Subject: FW: A/110/20/RES Land South of Water Lane Angmering Ap/17/OUT for the Bridge over the Black Ditch providing access to the approved development.

With regard to Planning Application A/110/20/RES further information and correspondence has become available since I submitted my representation.

25 September 2020

WATER LANE, ANGMERING
ACCESS BRIDGE
WSCC REF: 1772
GENERAL ARRANGEMENT

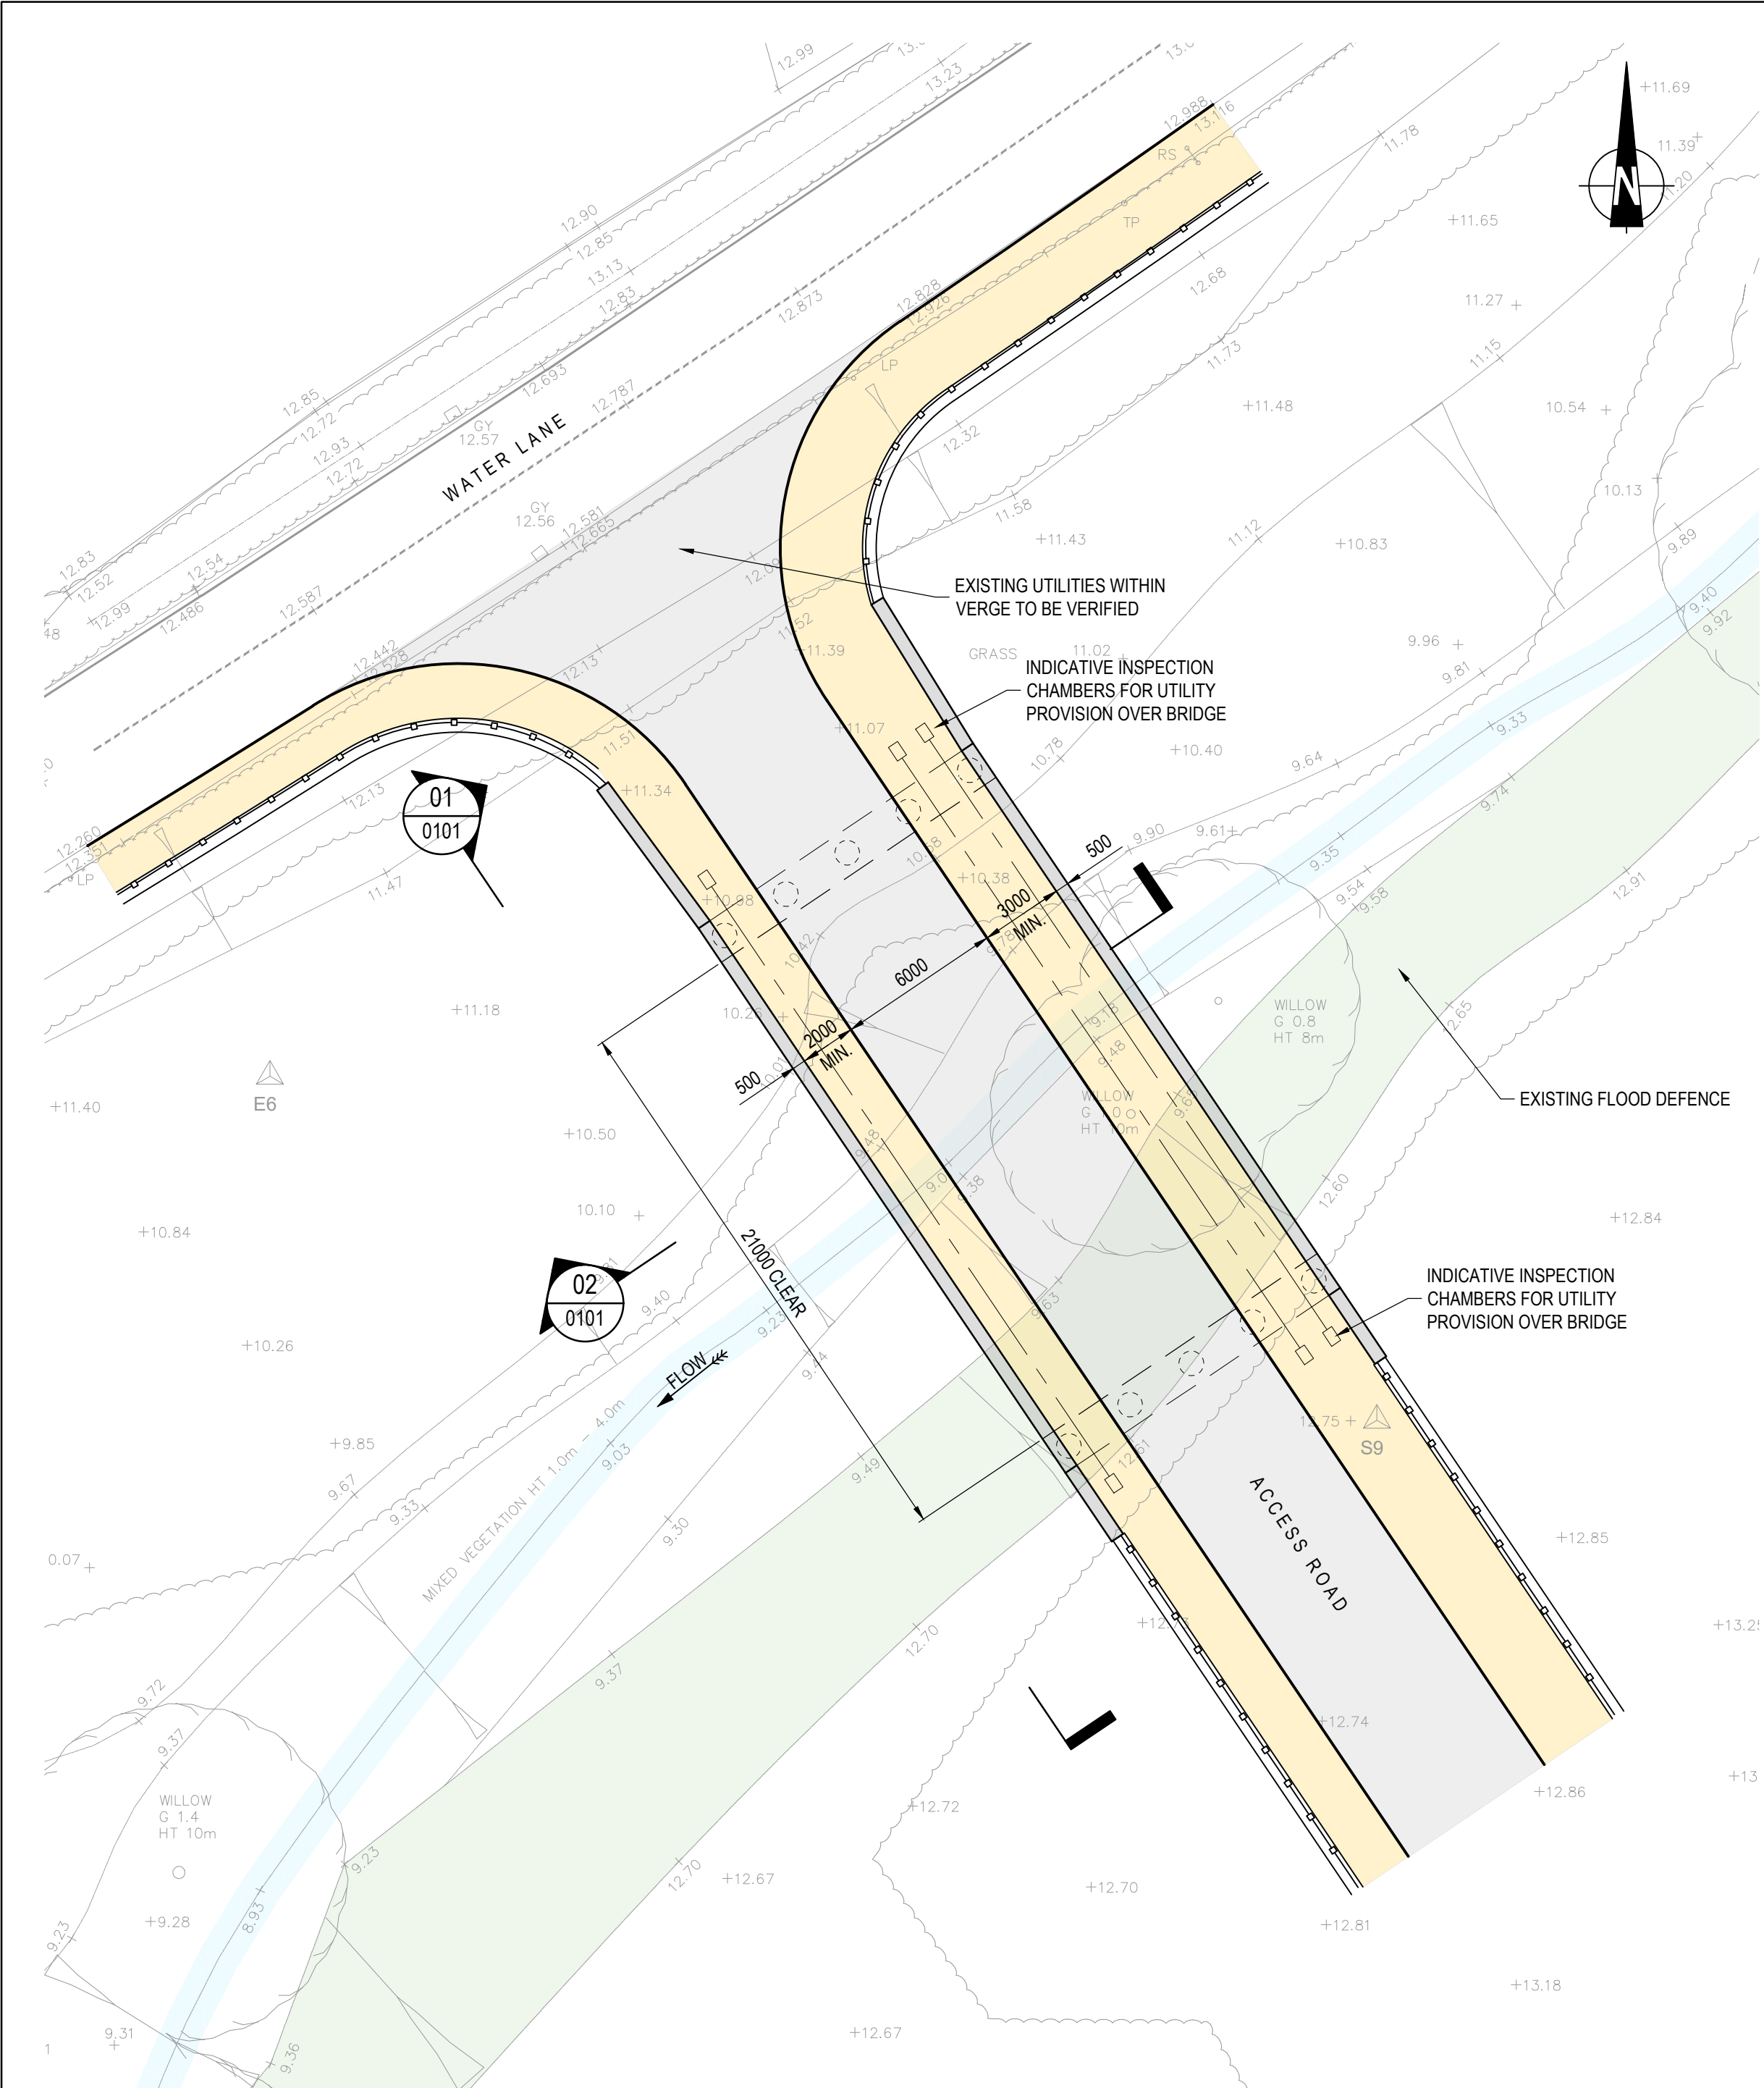
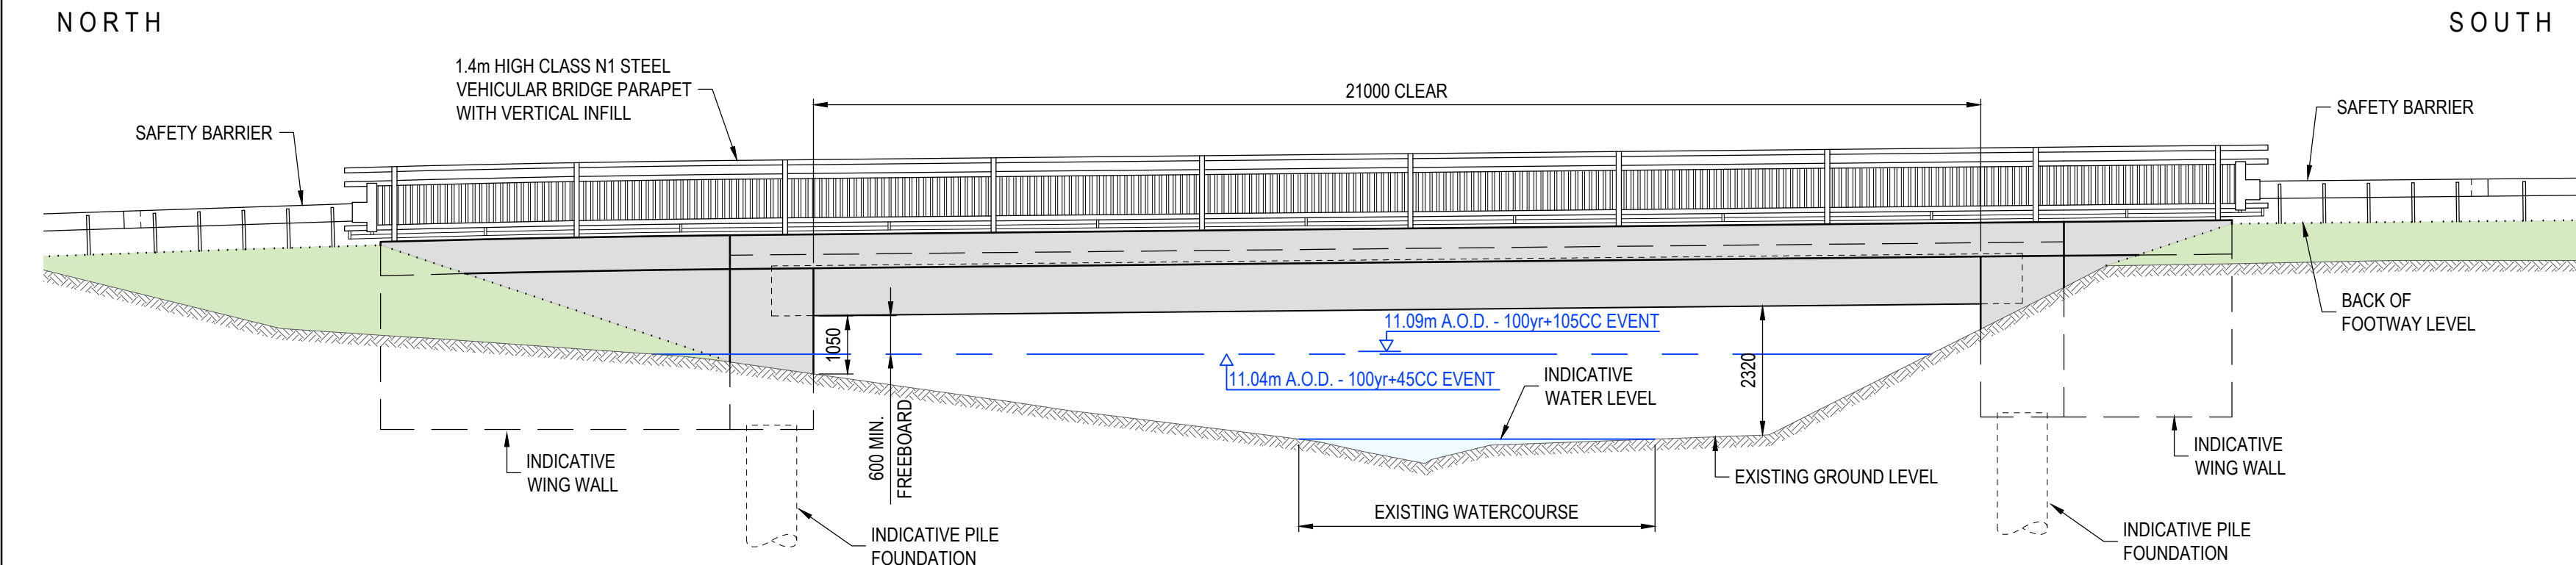
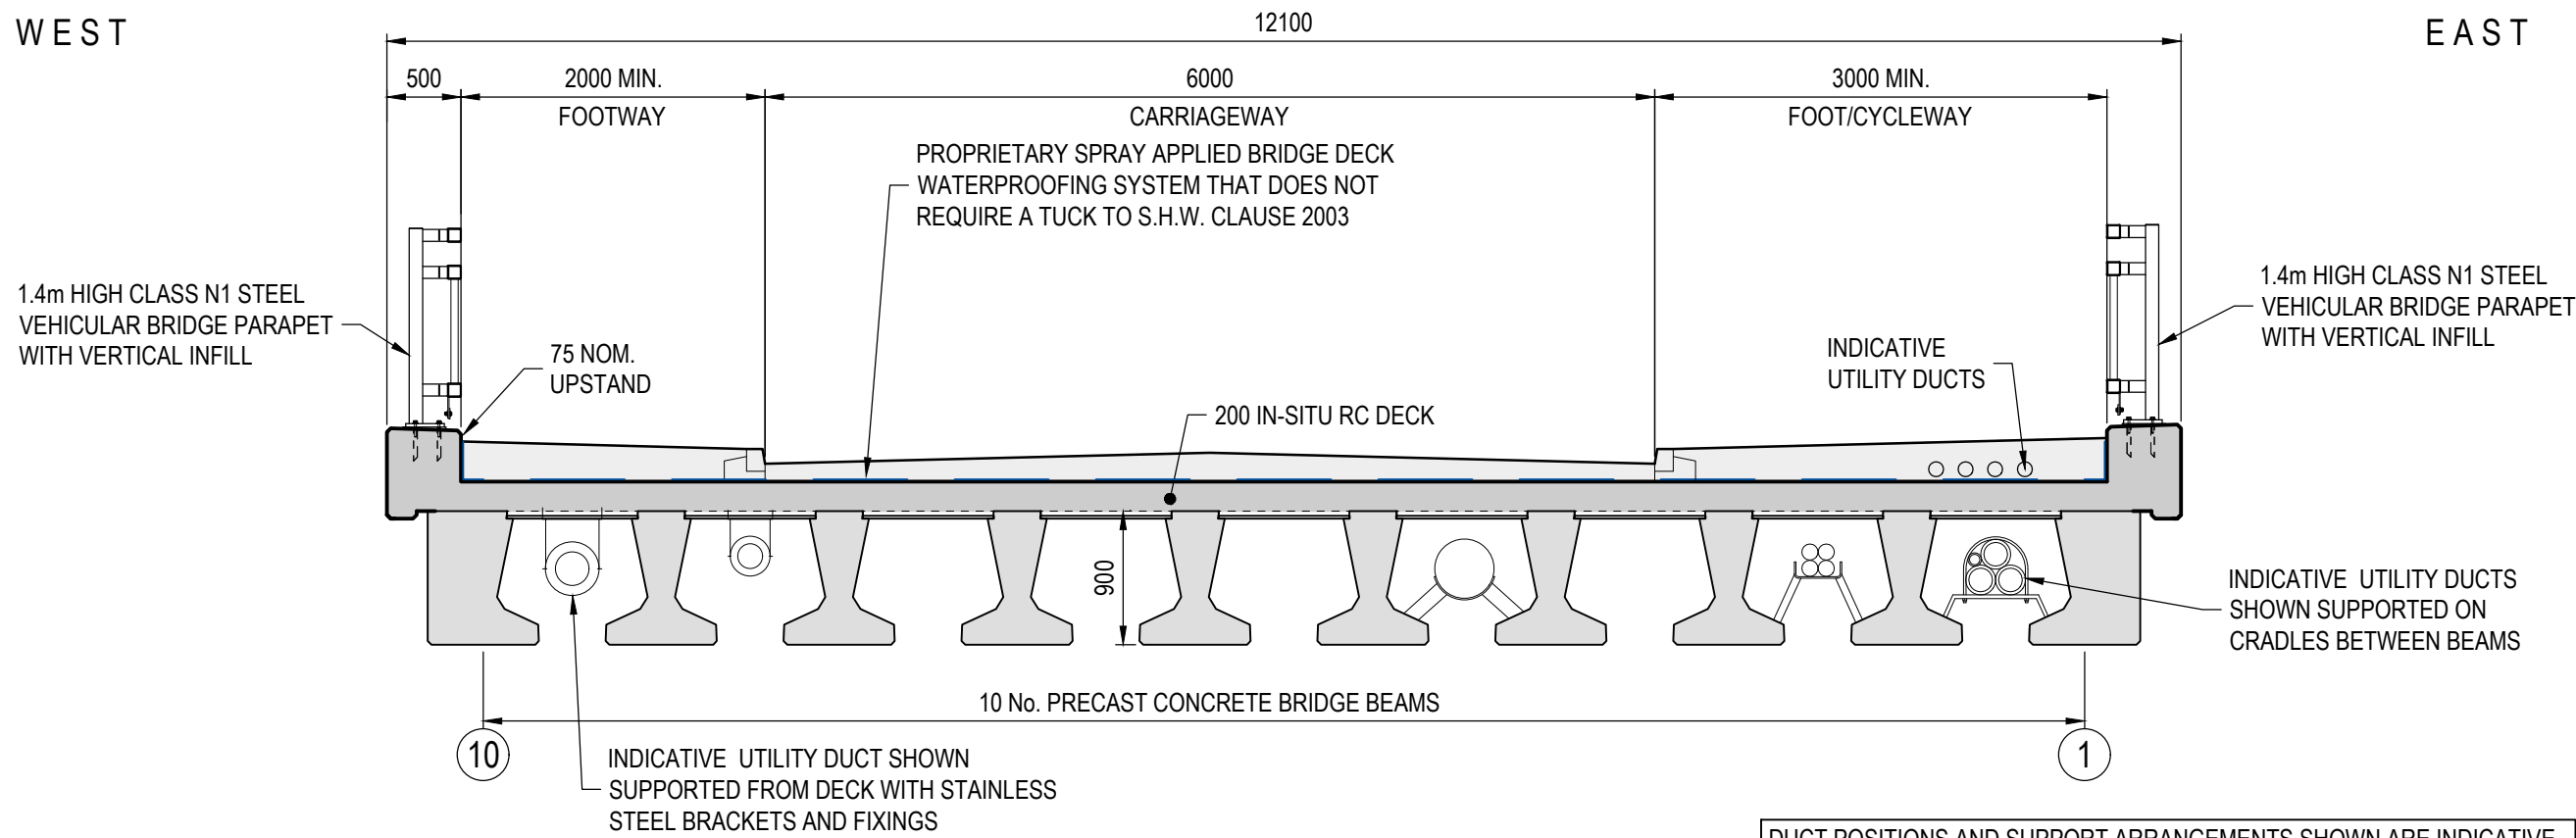
However, the consultation responses from your Council's drainage engineer and the Environment Agency have given me some hope that the aim to reduce flood risk overall can be achieved by constructing this access road which might otherwise be carried by the bridge covered by this application on a embankment through which Black Ditch flows are actively (rather than passively) controlled.

We understand from discussions with WSCC LLFA and the Environment Agency that a re-evaluation is being undertaken to establish if this crossing should be a culvert rather than a bridge in order to restrict flow and provide flood alleviation to the village downstream. We therefore do not recommend this application is approved at this time as proposals may fundamentally change.

The Environment Agency are presently part of ongoing discussions with Barnett David Wilson, Stantec, West Sussex County Council and Arun District Council with a view to replacing the bridge option with a box culvert, for the purpose of providing additional flood storage, as part of a local Flood Alleviation scheme for the village of Angmering.

This box culvert option will require an additional/revised Flood Risk Assessment (FRA) to demonstrate that:

- a) the additional storage is available,
- b) third parties shall not be affected by increased flood risk and
- c) whether this option could compromise the SUDS scheme in particular, the point of discharge location.

Please do not determine this Application until an alternative, that could offer a real benefit to Angmering, is properly evaluated.
